**Date:** 24 September 2021

**Planning Act 2008 – Section 88 and the Infrastructure Planning (Examination Procedure) Rules 2010 – Deadline 8: Comments on 3.1 Draft Development Consent Order - Revision 8.0 and 8.17 Draft Deed of Obligation - Revision 7.0**

**Application by NNB Generation Company (SZC) Limited for an Order Granting Development Consent for the Sizewell C Project**

DRAWING NO:
SZC-SZ0100-XX-000-DRW-100205

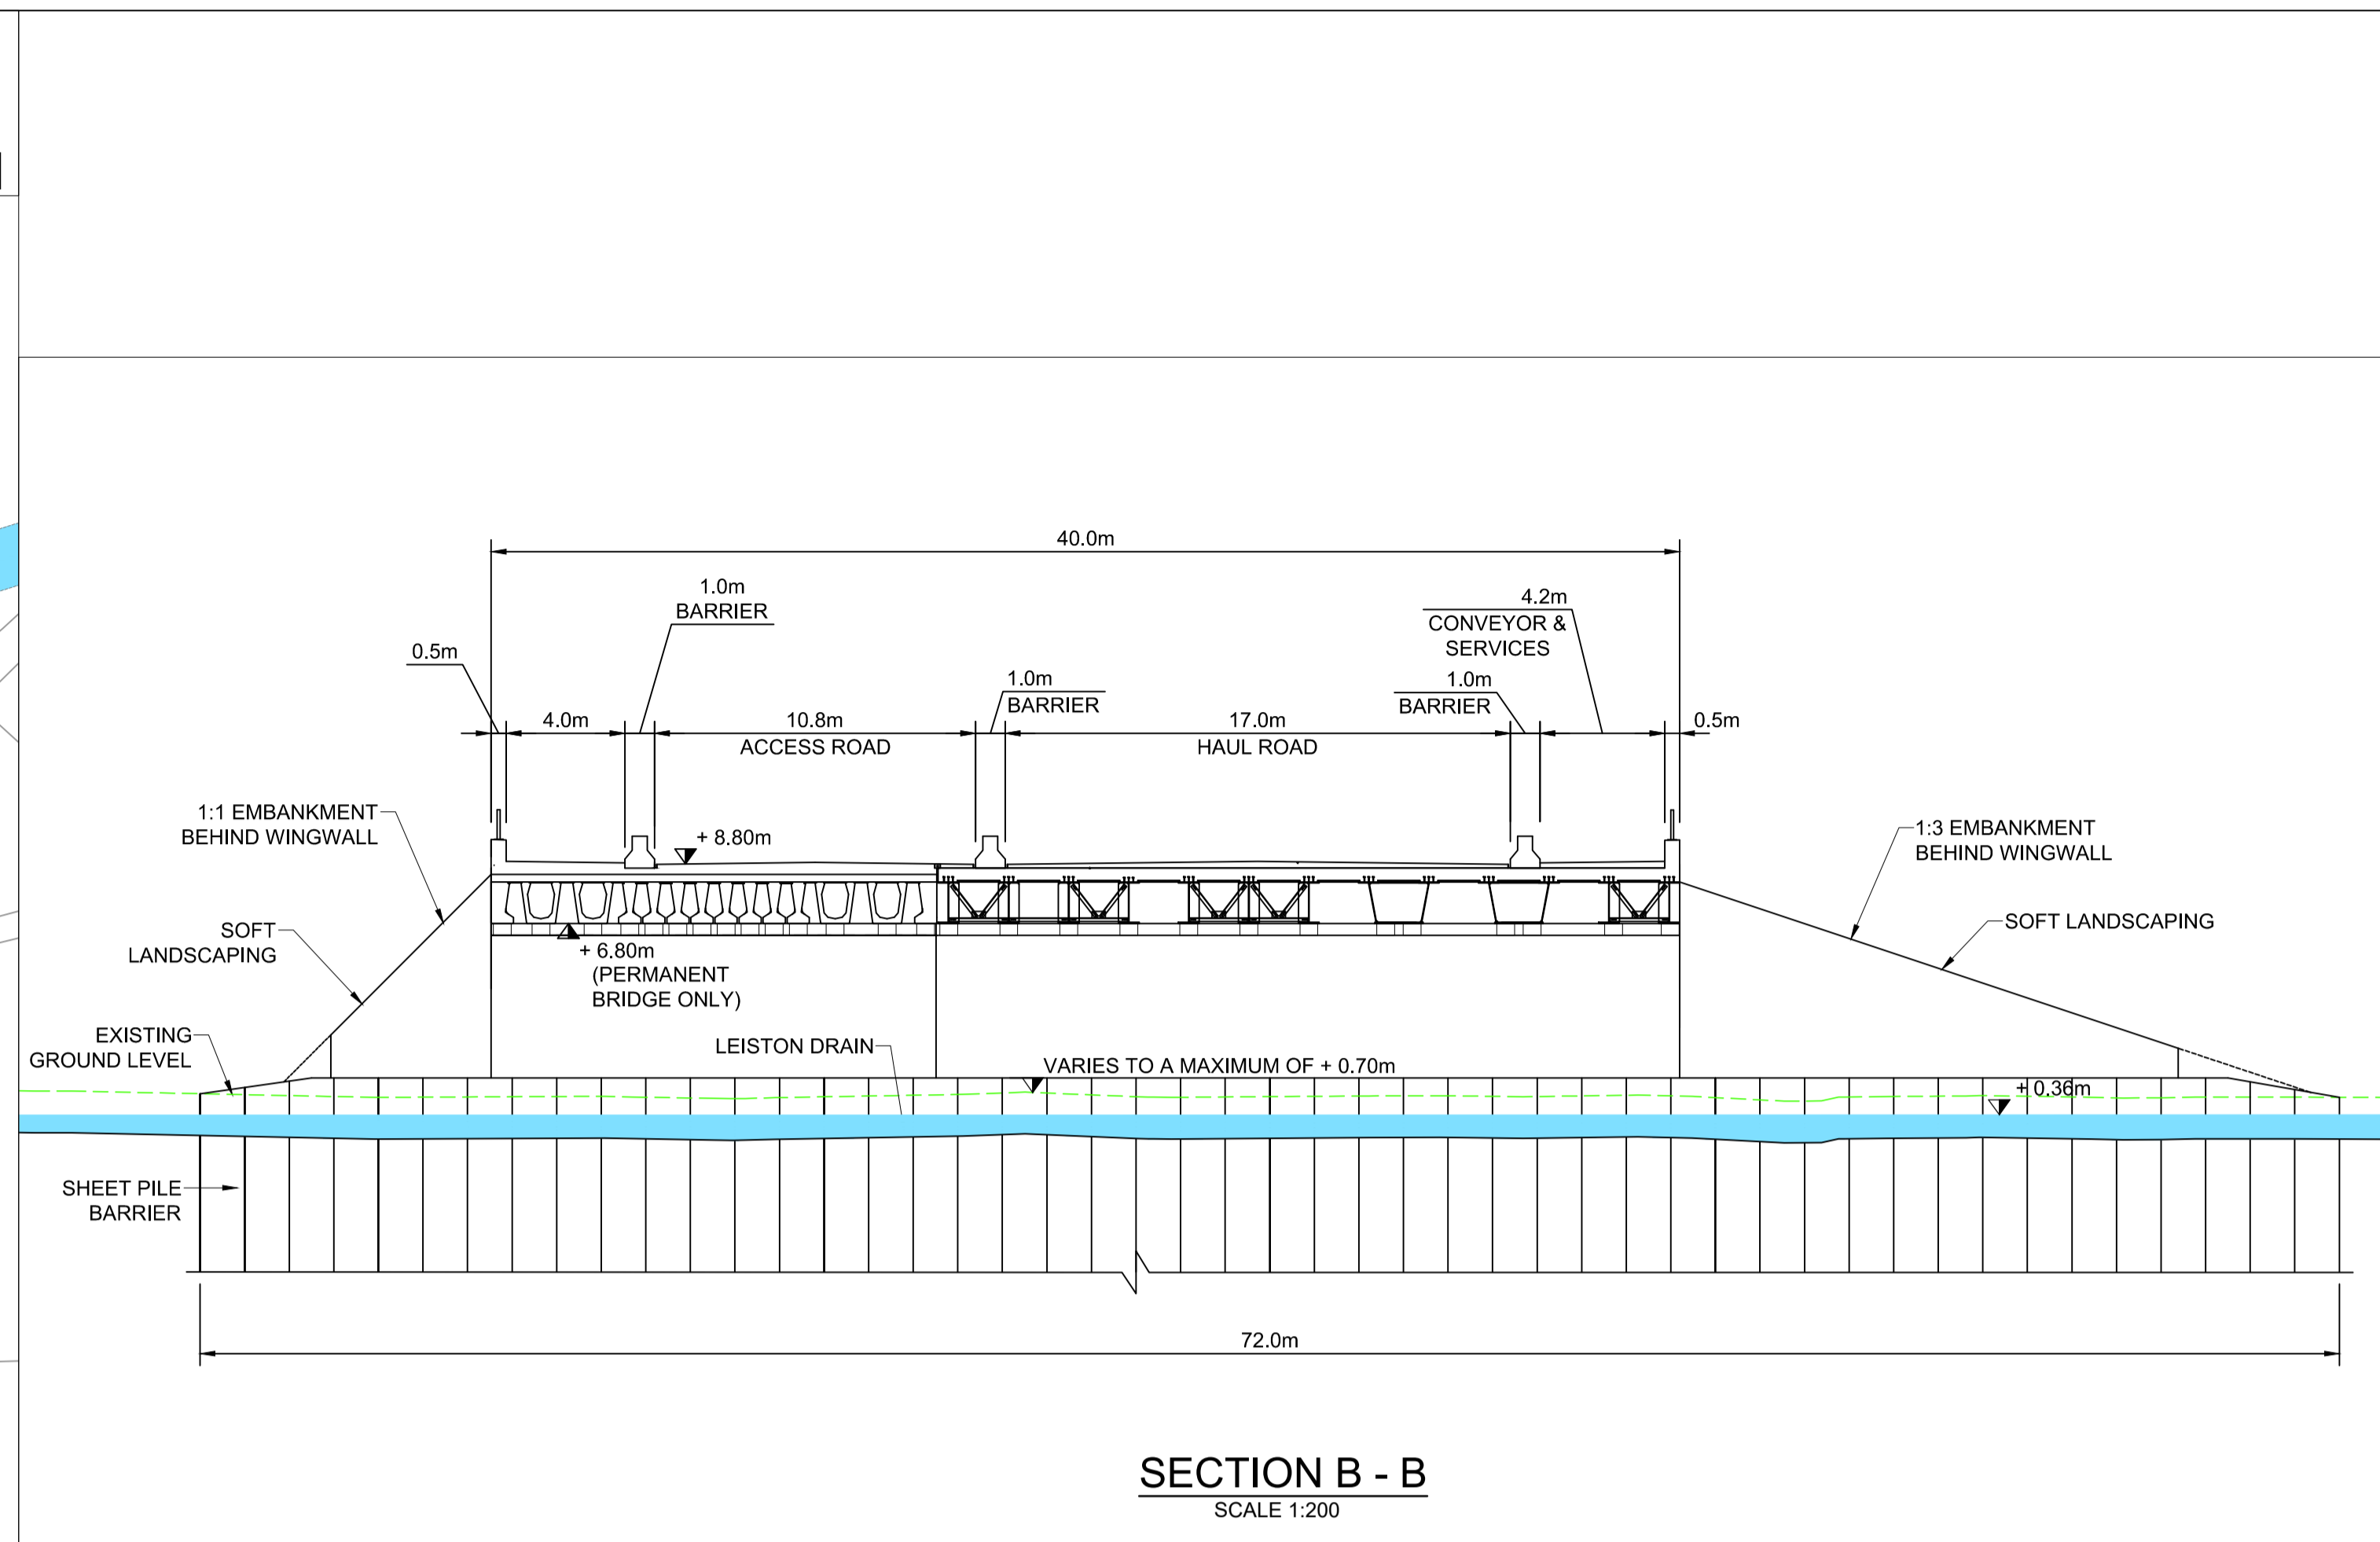
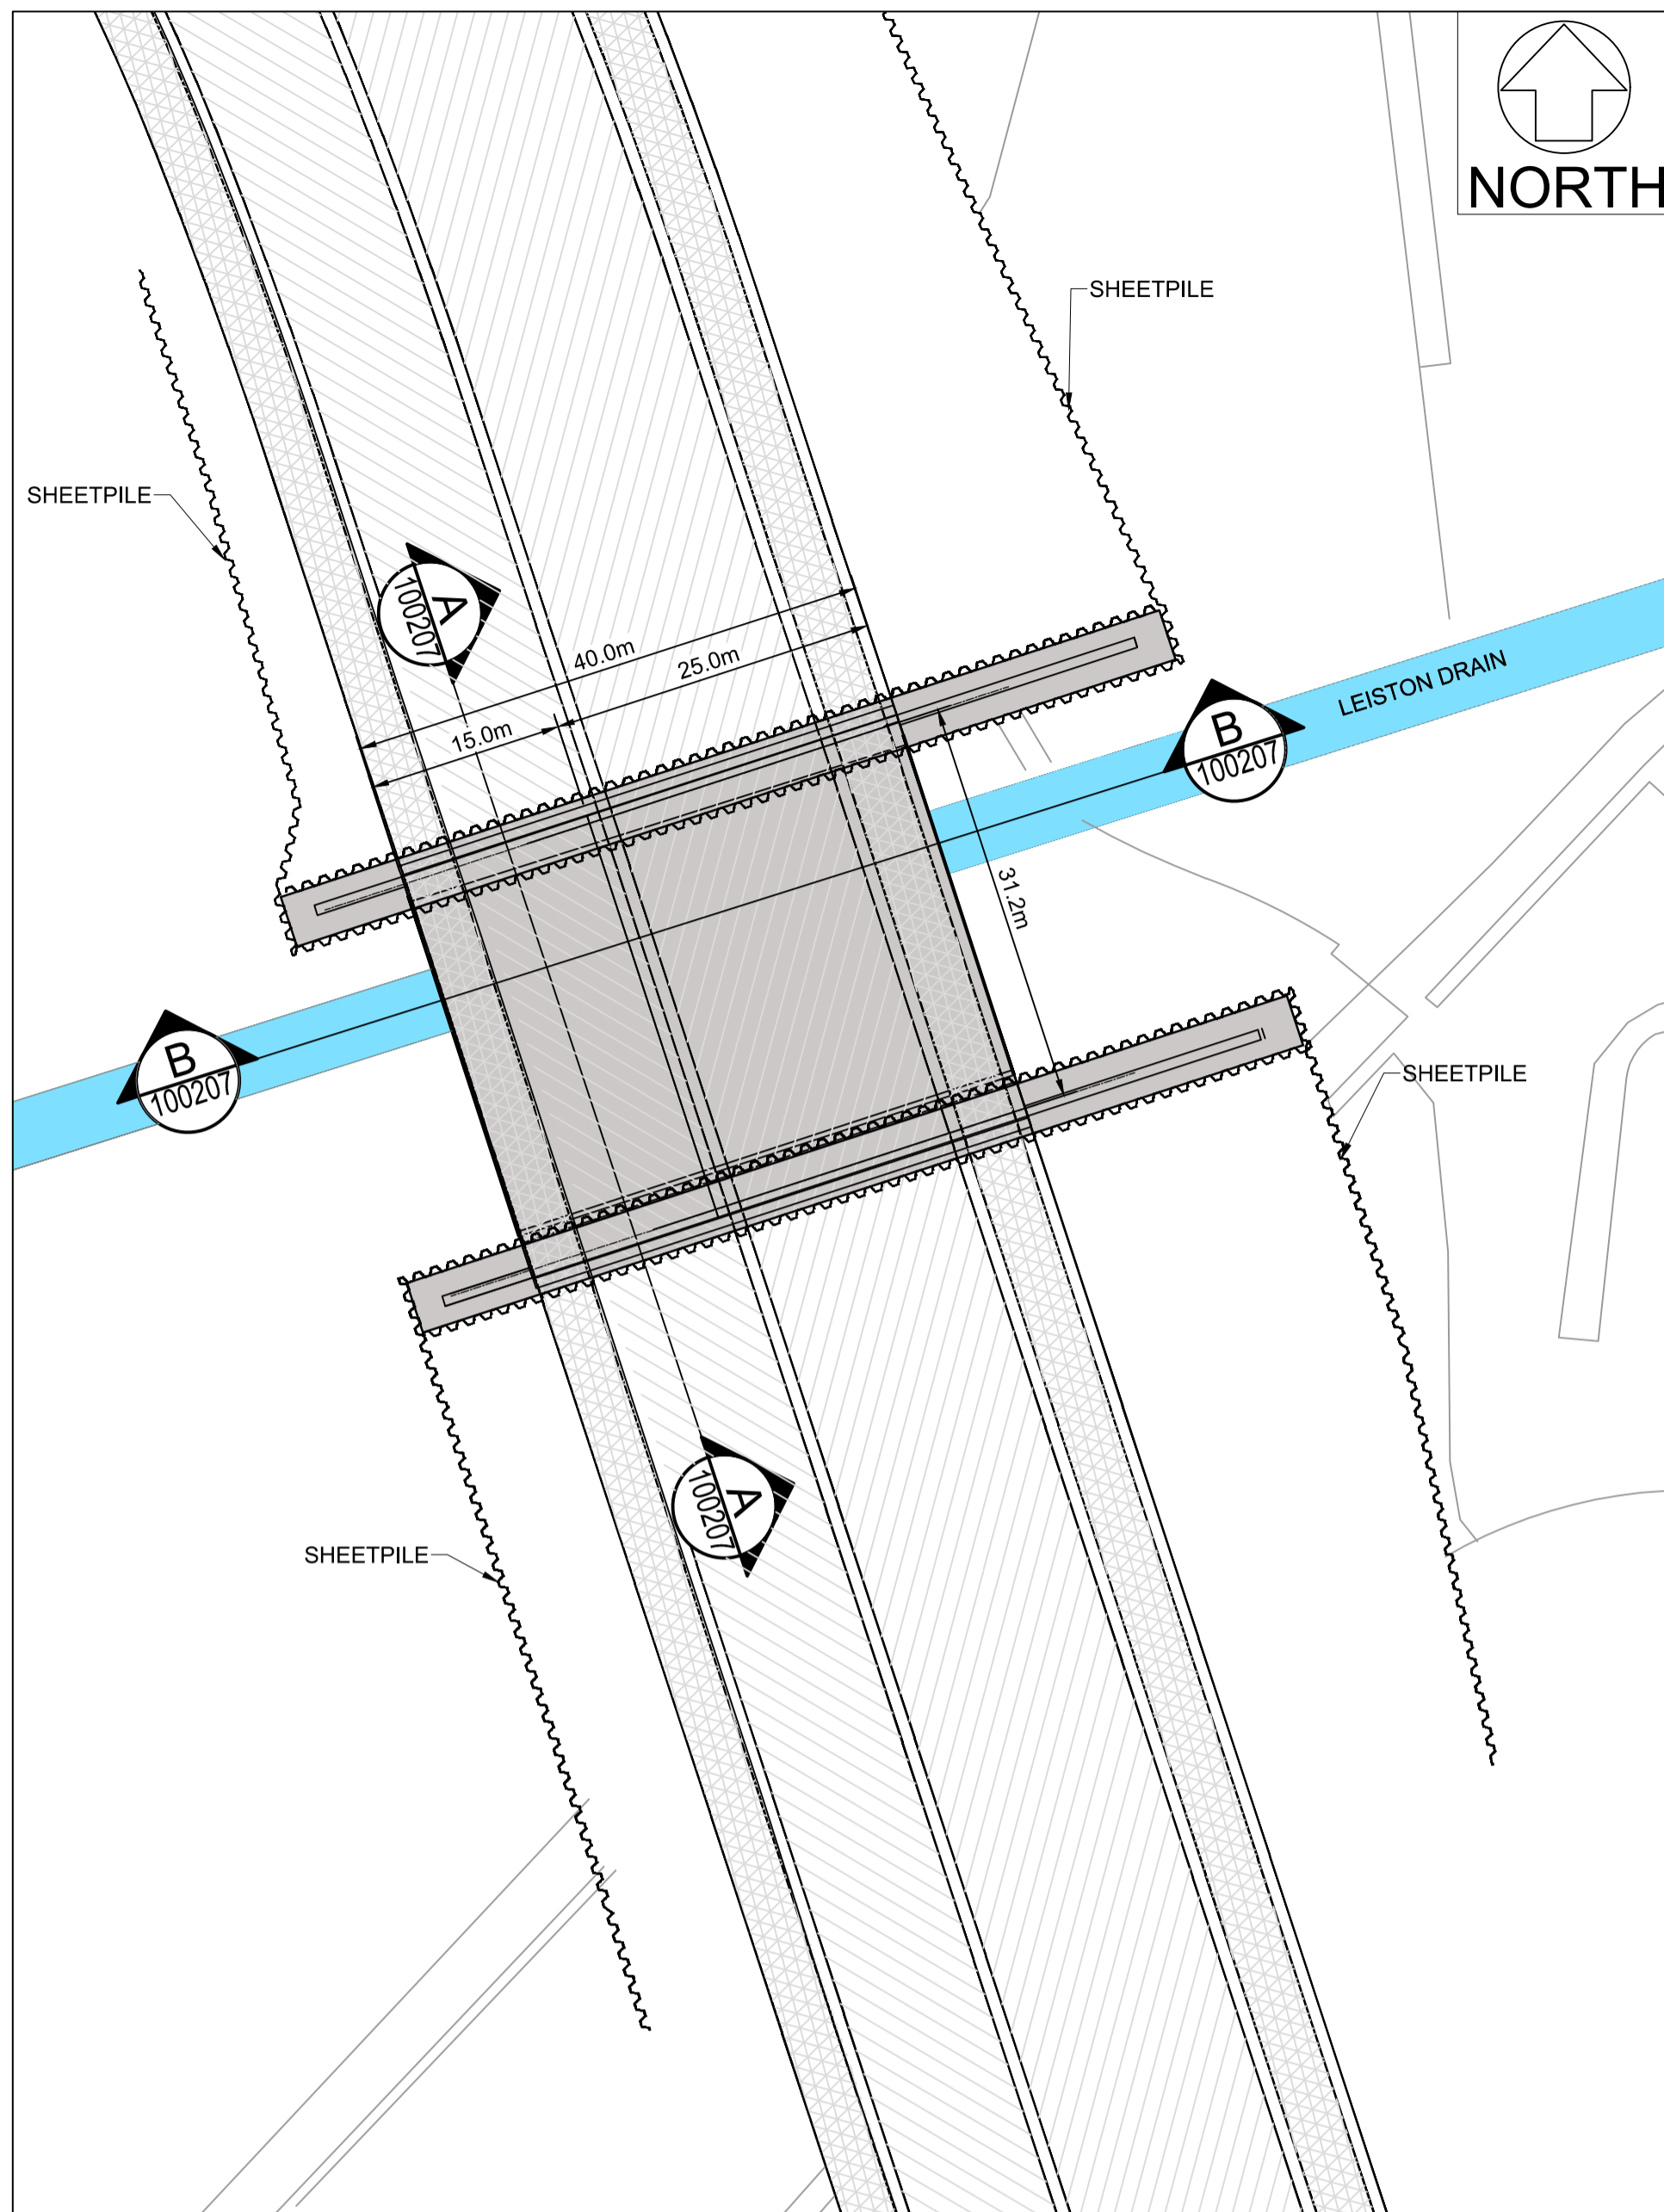
Section	Wording	Comments
<b>Schedule 2, Article 3 - Requirements</b>		
<p>Requirement 12C,</p> <p>Main development site: SSSI Crossing</p>	<p><b>Main development site: SSSI Crossing</b></p> <p>(1) Construction works within the SSSI must not commence until details of working methods within the SSSI land have been submitted to and approved by East Suffolk Council, following consultation with the Environment Agency and Natural England. The temporary SSSI Crossing must be built in general accordance with the following details:</p> <p>(a) Main Development Site SSSI Crossing (SZC Construction) (July 2021) (Drawing Ref: SZC-SZ0100-XX-000-DRW-100207);</p> <p>(b) Main Development Site SSSI Crossing (Bailey Bridge Stage) (July 2021) (Drawing Ref: SZC-SZ0100-XX-000-DRW-100209).</p> <p>(2) Construction of the permanent element of Work No. 1A(l) (SSSI Crossing) must not commence until details of the layout, scale and external appearance have been submitted to and approved by East Suffolk Council, following consultation with the Environment Agency and Natural England. The details must:</p> <p>(a) be in general accordance with the Main Development Site SSSI Crossing (SZC Operational) (July 2021) (Drawing Ref: SZC-SZ0100-XX-000-DRW-100205);</p> <p>(b) include layout and scale which has:</p> <p>(i) a crest no lower than 8.6m (AOD);</p>	<p>The potential environmental impacts, including Water Framework Directive concerns, relate to both the construction and permanent elements of the SSSI Crossing.</p> <p>We welcome that the Environment Agency is now proposed as a consultee in discharging (1) Construction works, as well as for (2) permanent elements.</p>

<p>(ii) a soffit no lower than 6.8m (AOD) at its intersection with the Leiston Drain; and</p> <p>(iii) a span no wider than 15m.</p> <p>(c) include a flood risk monitoring and adaptive defence plan that sets out the periodic monitoring proposals for the SSSI Crossing and the trigger point for when the crest height of the SSSI Crossing would need to be increased to 10.5m (AOD).</p> <p>(d) a timetable for the works, including a timetable for the return of temporary SSSI land.</p> <p>(3) Work No. 1A(I) (SSSI Crossing) must be carried out in accordance with the approved details.</p>	
<p>Requirement 22A,</p> <p>Associated developments: Landscape works</p>	<p><b>Associated developments: Highway landscape works</b></p> <p>(1) Work No. 11 and Work No. 12 must not be commenced until details of the landscape works for that work have been submitted to and approved by East Suffolk Council in consultation with the Environment Agency.</p> <p>(2) The details referred to in paragraph (1) must be in accordance with the Approved Plans (Schedule 7), unless otherwise agreed by East Suffolk Council.</p> <p>(3) Landscape works must be carried out in accordance with the approved details.</p> <p>(4) Landscape works in relation to Work No. 11 must be managed in accordance with the Two Village Bypass Landscape and Ecology Management Plan, unless otherwise agreed with East Suffolk Council.</p>	<p>This requirement secures key environmental mitigation and monitoring measures.</p> <p>We welcome that the Environment Agency is now proposed as a consultee for any future revision of Sizewell Link Road or Two Village Bypass Landscape and Ecology management plans.</p>
